Application No: 320110768 P

Application for Planning Permission. Town and Country Planning Act 1990

ALTERATIONS TO ACCESS, INCLUDING RE-SITING GATEWAY FURTHER BACK FROM ROAD TO CREATE A LARGER SPLAY. EXTENDING THE EXISTING WALL TO REACH THE NEWLY POSITIONED GATEWAY. ERECTING A POST + RAIL FENCE FROM THE NEWLY POSITIONED GATEWAY TO THE EXISTING FARM BUILDINGS.

RE: Alterations to access
 AT: Law Farm, Trapp Lane, Simonstone

Title: Law Farm
Trapp Lane
Simonstone
BB12 7JE
PROPOSED SITE PLAN

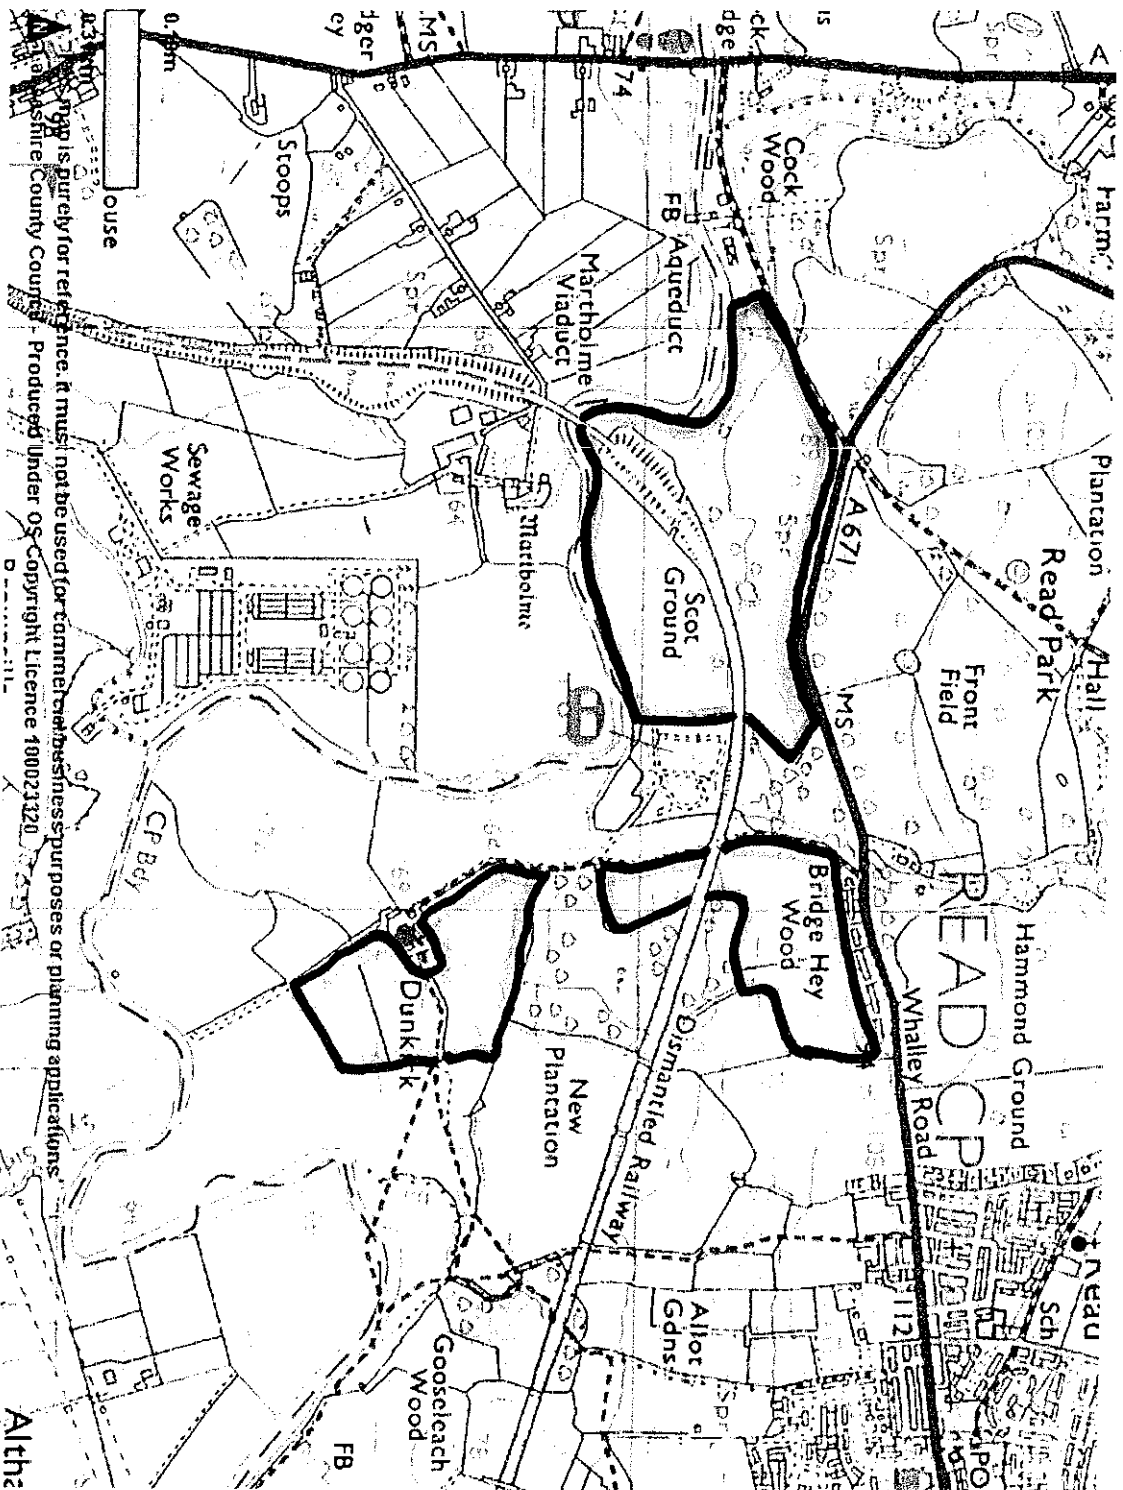
- Finally, please would you be able to add the width dimension to the proposed access?

I attach a revised proposed layout dwg - could you please supercede the one currently in your possession.
